**RE: Transmittal of Comments – Cabin Mountain Tree Farm Tracts Large Lot (LL-08-06)
Cabin Mountain Tracts Large Lot (LL-08-07)**

To: Trudie Pettit, Staff Planner
From: Michelle Geiger, Plans Examiner Kittitas County Community Development Services
Date: May 30, 2008
Re: Cabin Mountain Tree Farm Tracts Large Lot, LL-08-06 & Cabin Mountain Tracts Large Lot, LL-08-07

TO: Trudie Pettit, Community Development Services
FROM: Randy Carbary, Planner II *RC*
DATE: May 7, 2008
SUBJECT: Cabin Mountain Tracts Large Lot Subdivision LL-08-00007

TO: Trudie Pettit, Community Development Services
FROM: Randy Carbary, Planner II *RC*
DATE: May 30, 2008
SUBJECT: Cabin Mountain Tree Farm Tracts Large Lot Subdivision LL-08-00006

CABIN MOUNTAIN TRACTS LARGE LOT SUBDIVISION A PORTION OF SECTION 8, TOWNSHIP 20N., RANGE 13E., W.M. KITKITAS COUNTY, WASHINGTON

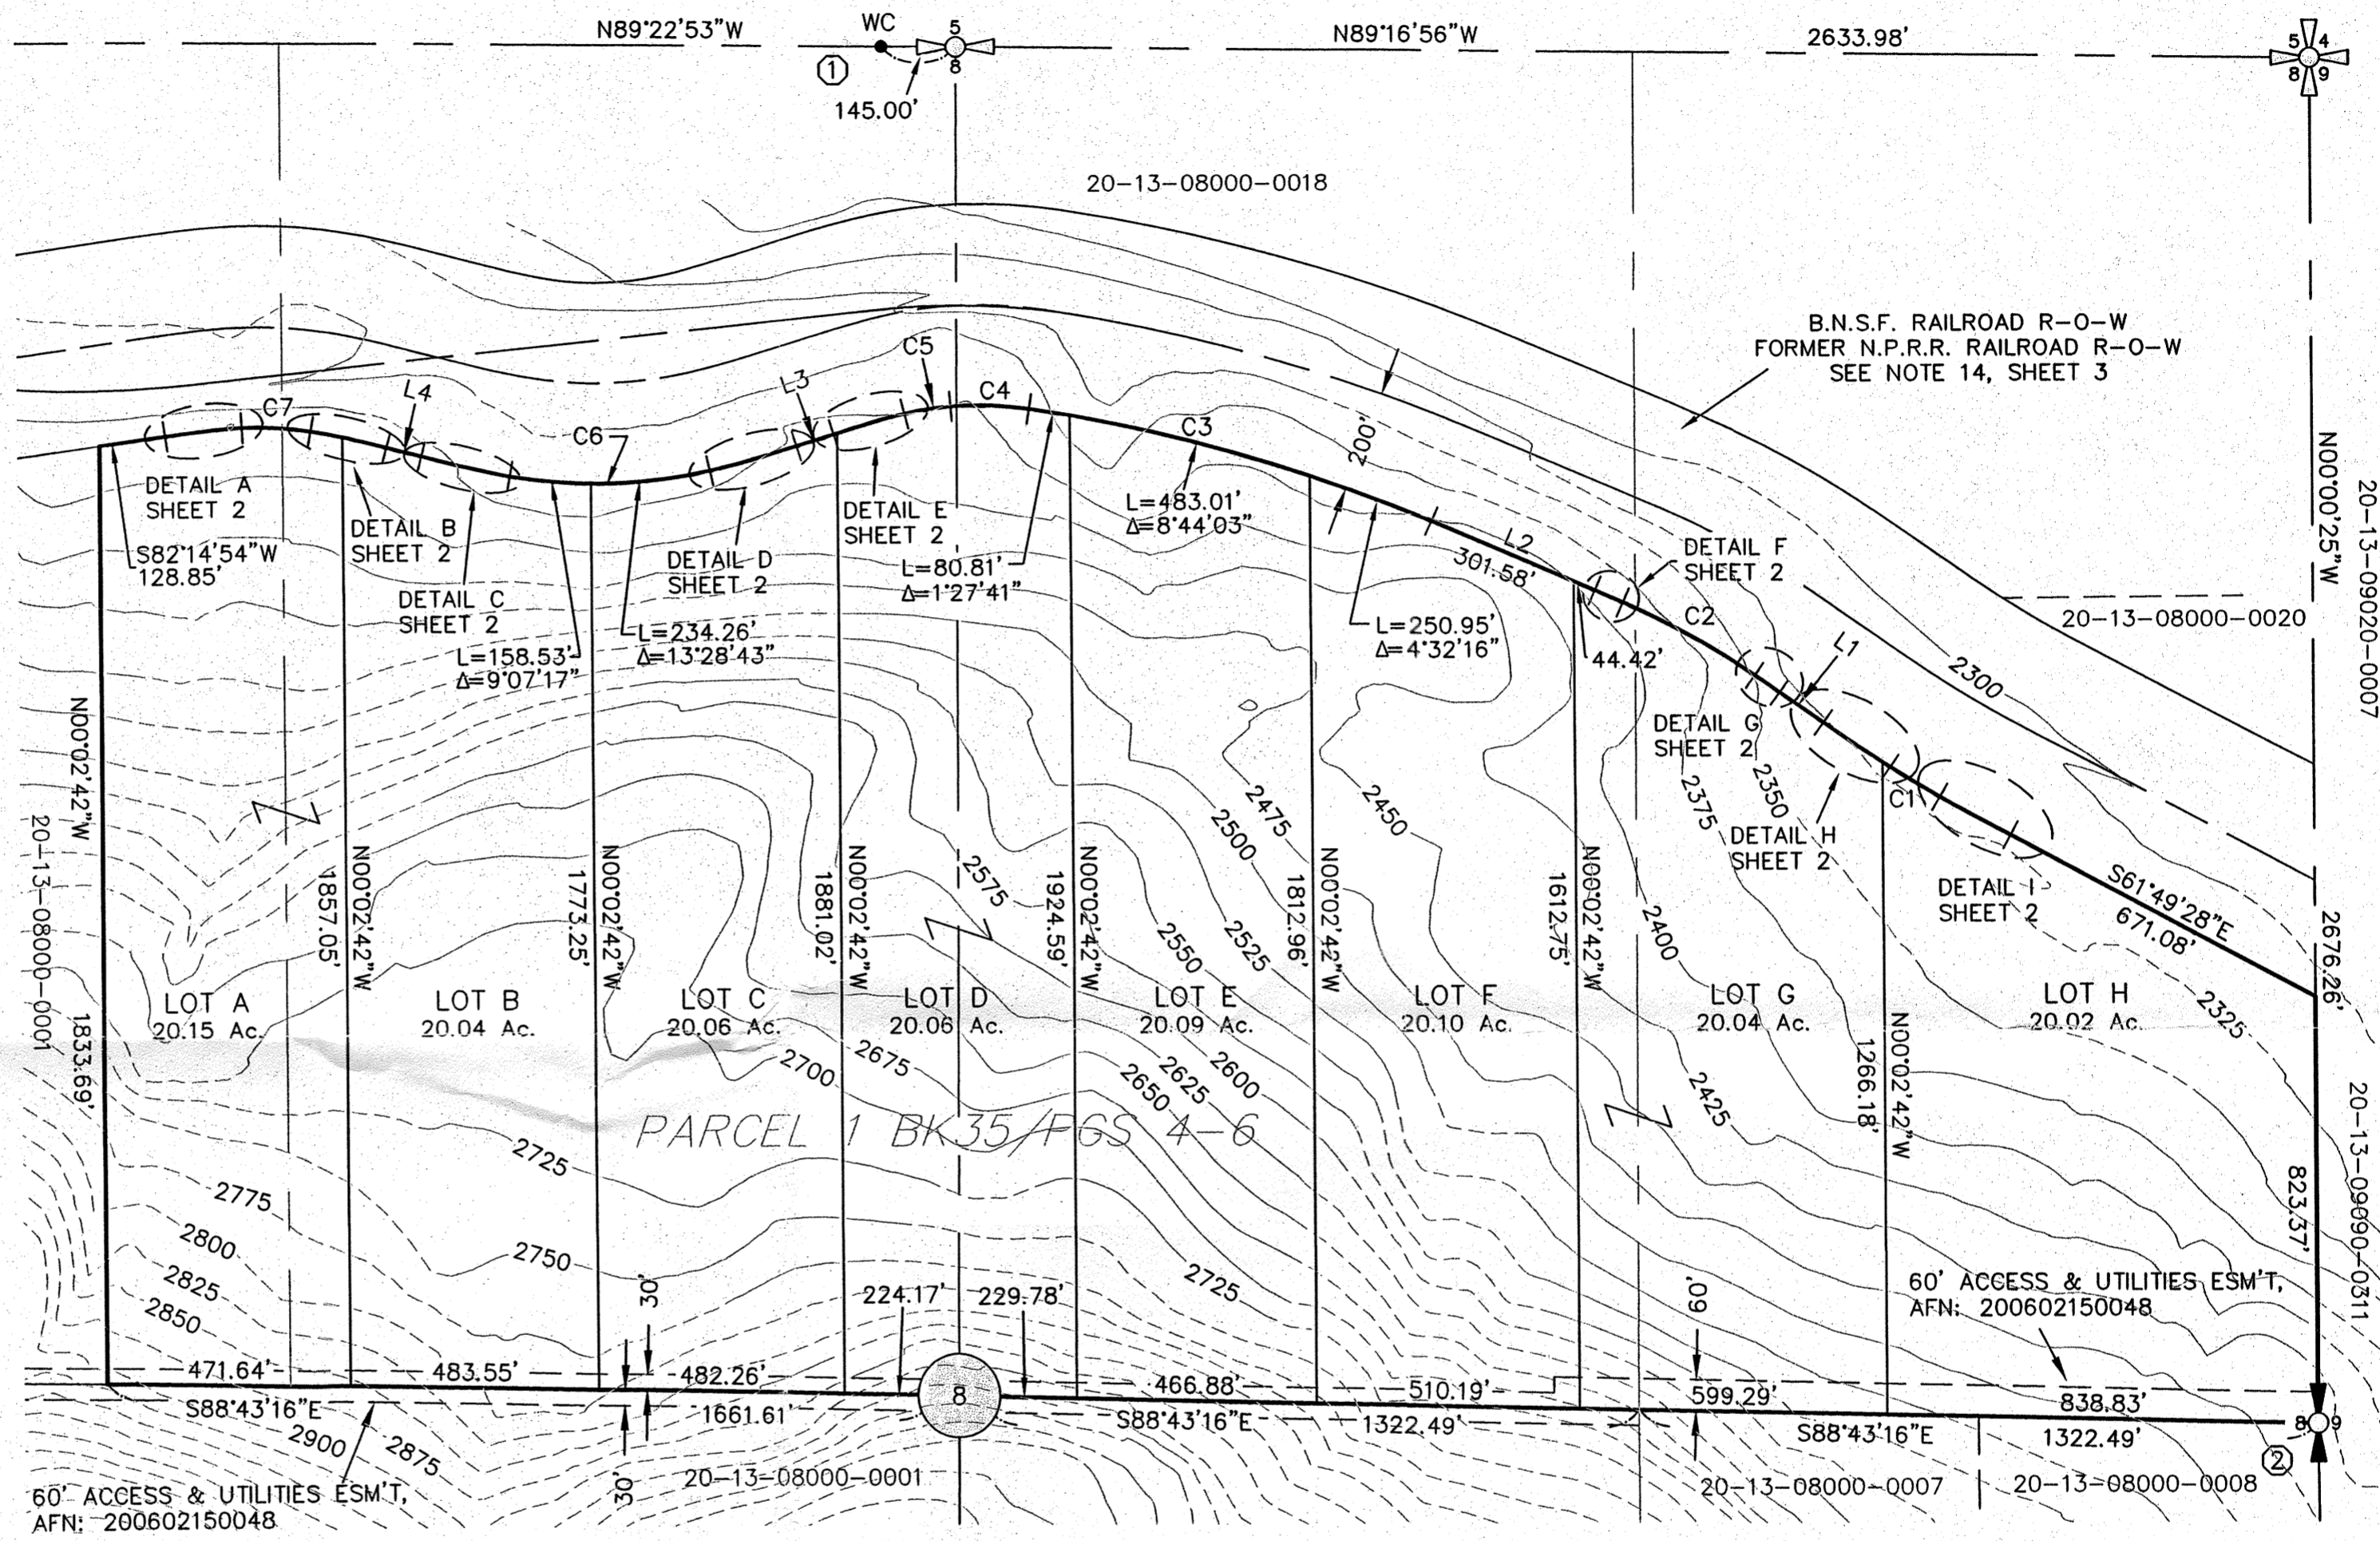
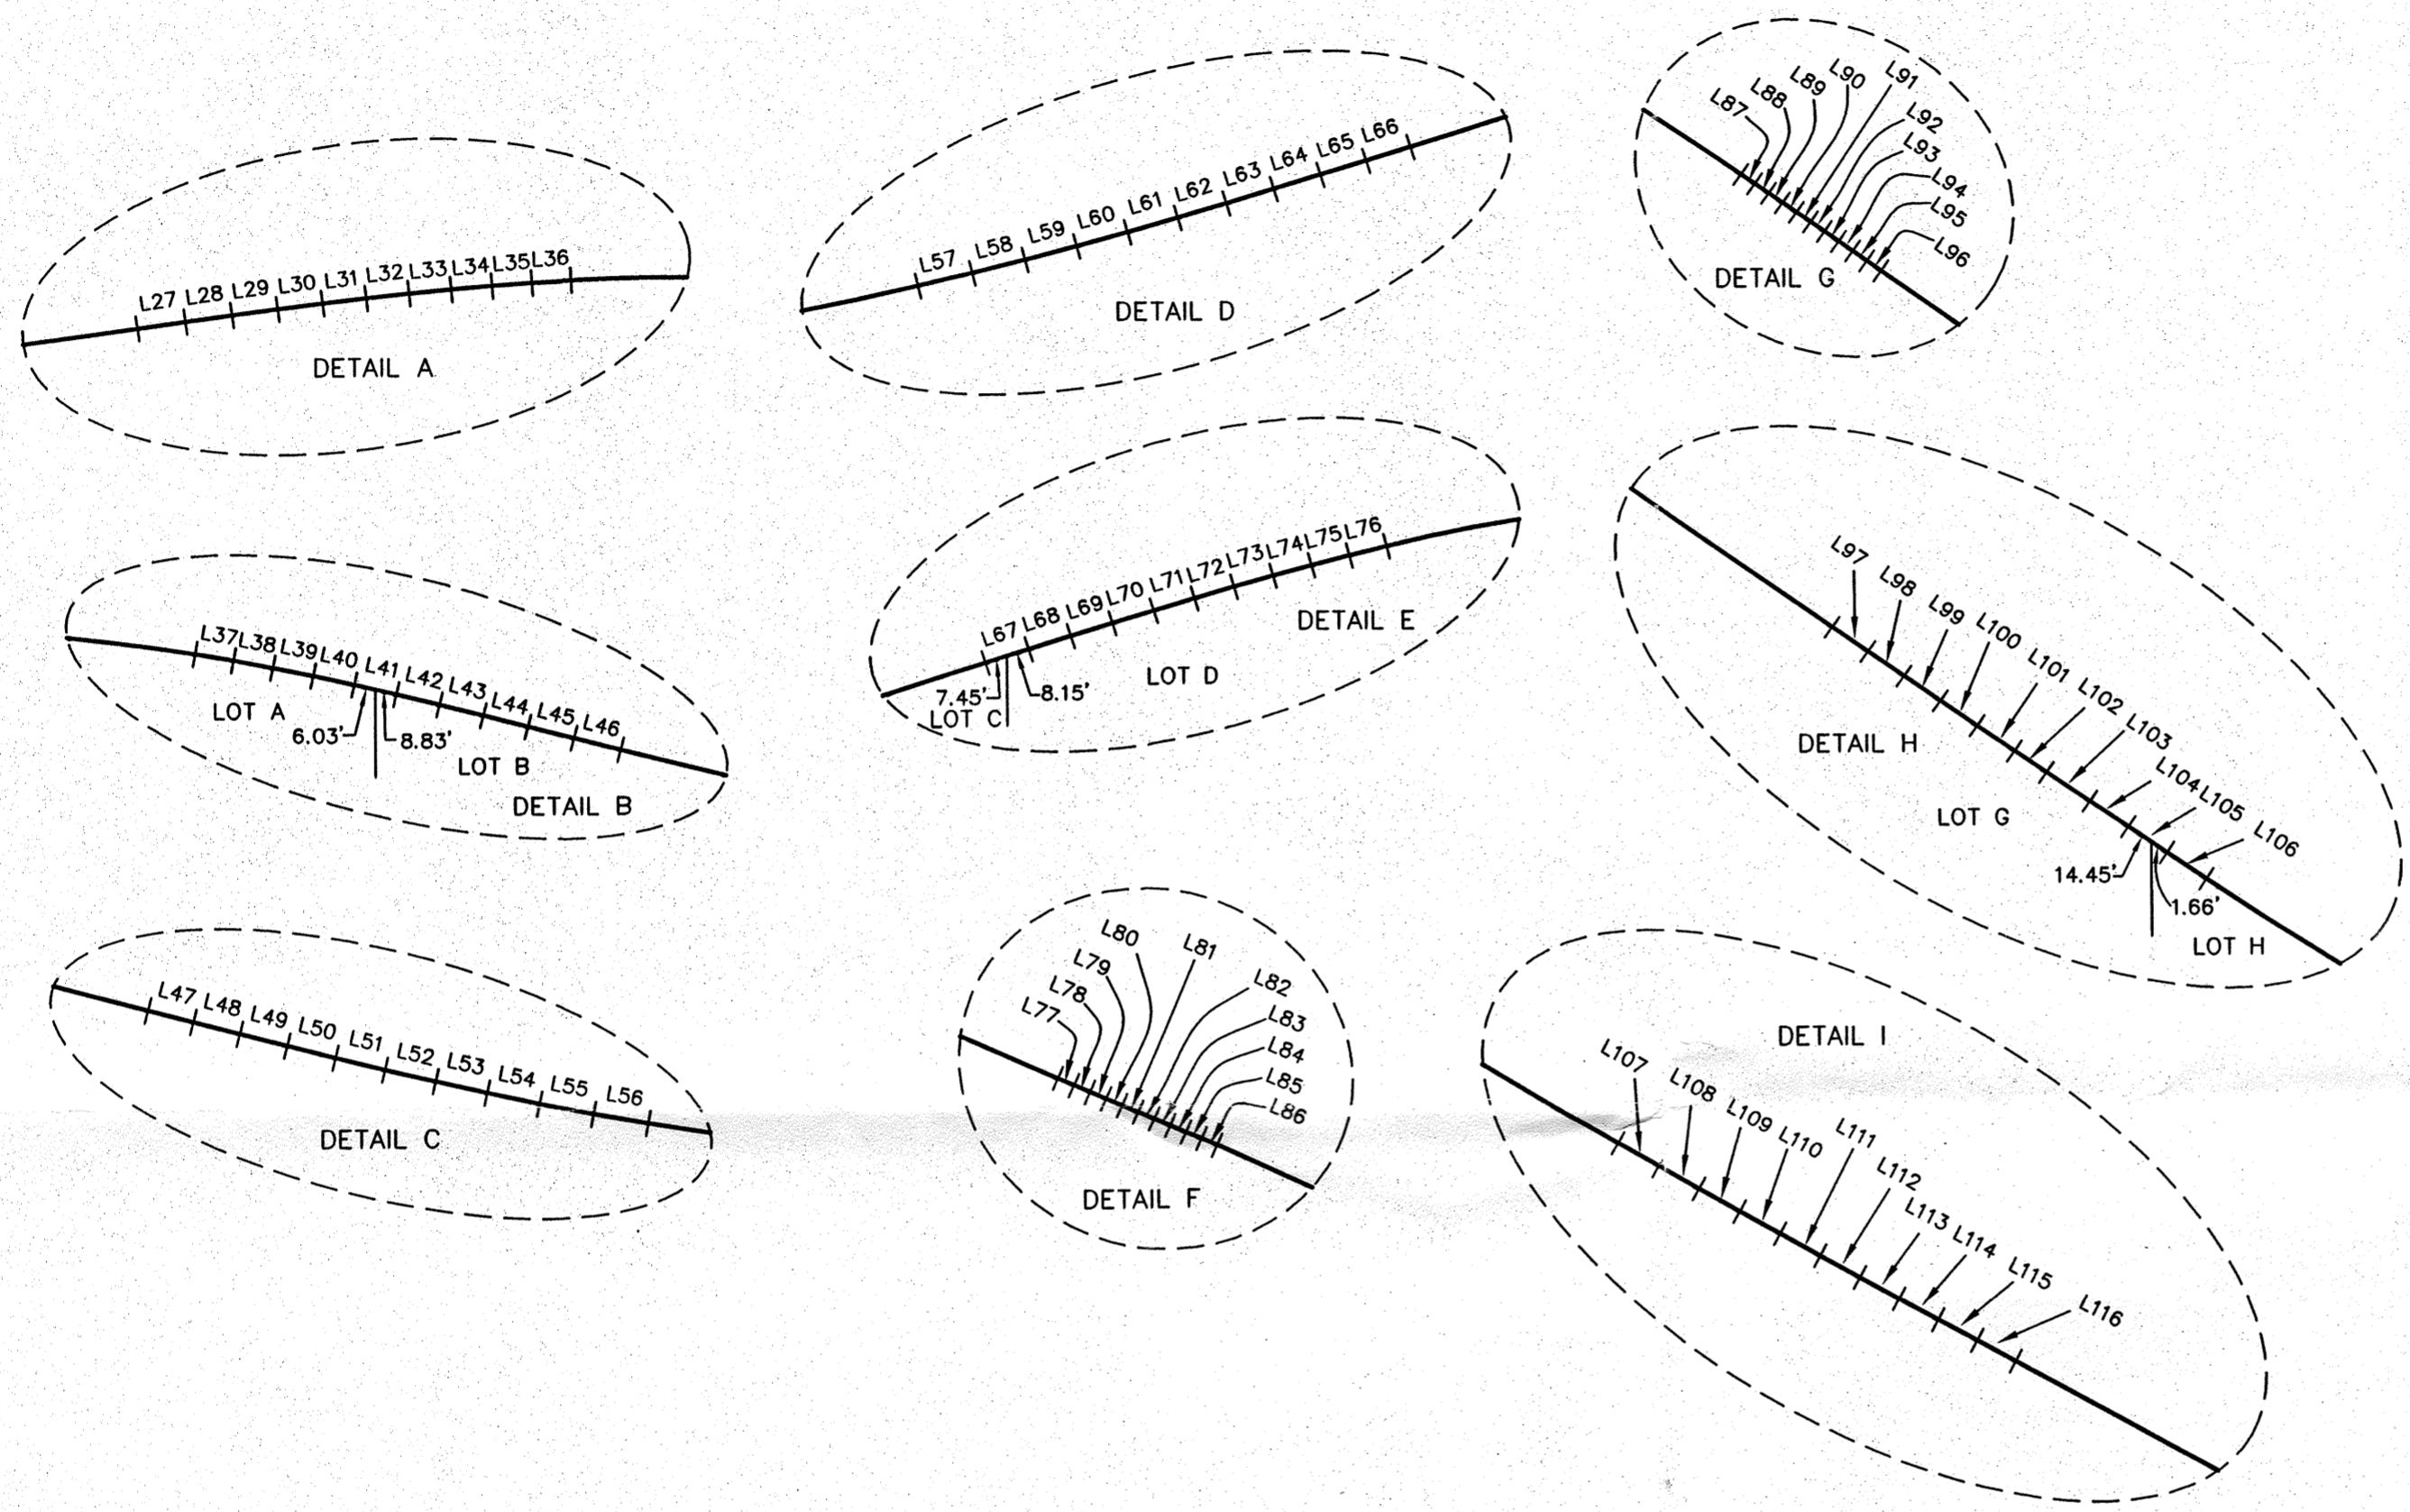
1. **Cul-de-Sac:** No cul-de-sac or turn around area is identified on the Large Lot Subdivision application. A cul-de-sac turn-around having an outside right-of-way easement diameter of at least 110 feet shall be constructed at the closed end of all dead-end roads serving 3 or more lots. The driving surface shall be at least 96 feet in diameter. Cul-de-sacs must also conform to the requirements specified by the 2006 International Fire Code. Contact the Fire Marshal regarding any additional cul-de-sac requirements.

The location of the cul-de-sac or turn around area shall be depicted on the face of the Large Lot Subdivision application, prior to final approval of the Large Lot Subdivision., regardless of its location.

- a. Access easements shall be a minimum of 60' wide. The roadway shall have a minimum width of 20', with 1' shoulders, for a total width of 22'.
 - b. Minimum centerline radius will be 60'.

- c. The surface requirement is for a minimum gravel surface depth of 6".
 - d. Maximum grade is 12%.
 - e. Stopping site distance, reference AASHTO.
 - f. Entering site distance, reference AASHTO.
